From: Liz Annalls [REDACTED]
Sent: 18 March 2020 12:40
To: Planning.Responses <Planning.Responses@arun.gov.uk>
Subject: RE: Planning Consultation on: Y/24/20/PL

App No: Y/24/20/PL

Address: Fresh Acres Nursery Yapton Lane Walberton BN18 0AS

Proposal: Change of use from Horticultural to storage of containers, caravans & garden equipment, erection of palisade fencing to front of site behind the existing hedgerow, increase planting buffer to front & sides. No. CCTV cameras.

3.2.1 Isolines representation, Horizontal Spillage (E)

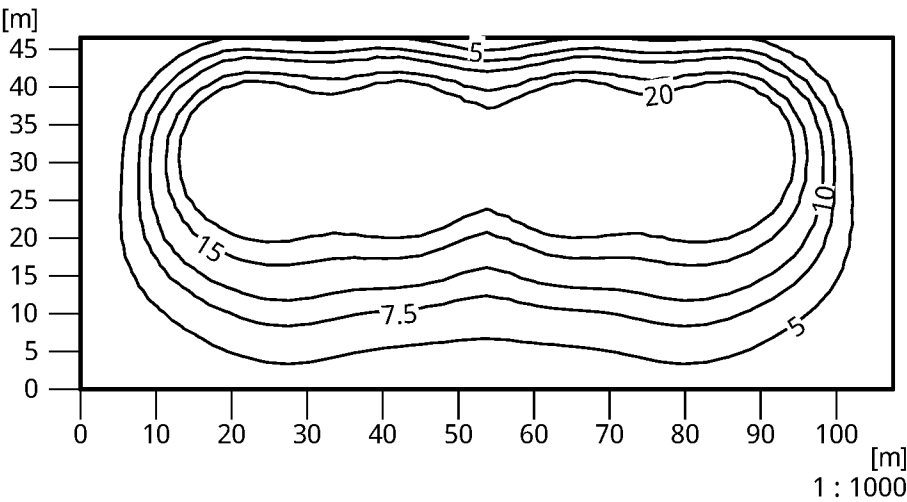
The lighting scheme for the site will need to take into consideration the presence of bats in the local area and the scheme should minimise potential impacts to any bats using the trees, hedgerows and buildings by avoiding unnecessary artificial light spill through the use of directional light sources and shielding.
